# CITY OF ALBUQUERQUE

May 11, 2022

**Re: Chase Bank - ATM**  
**2529 San Mateo NE**  
**Traffic Circulation Layout**  
Architect's Stamp 04-29-2022 (H17-D049)

DETAILS
SHEET 5 OF 5
A-3R

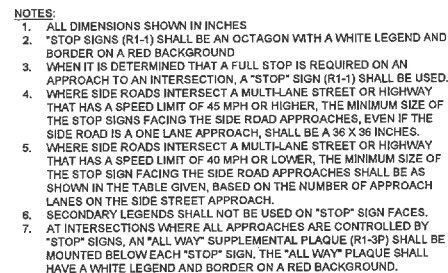
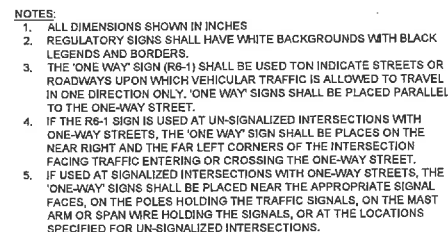
- The 'Do Not Enter' sign will need to be on both sides of the exit lane.
- Sign Face detail for Stop sign (R1-1) and Do Not Enter sign (R5-1) needs to be added to details.

- The pavement marking text 'Do Not Enter' detail needs to be added.
- Provide complete details for proposed pavement markings.
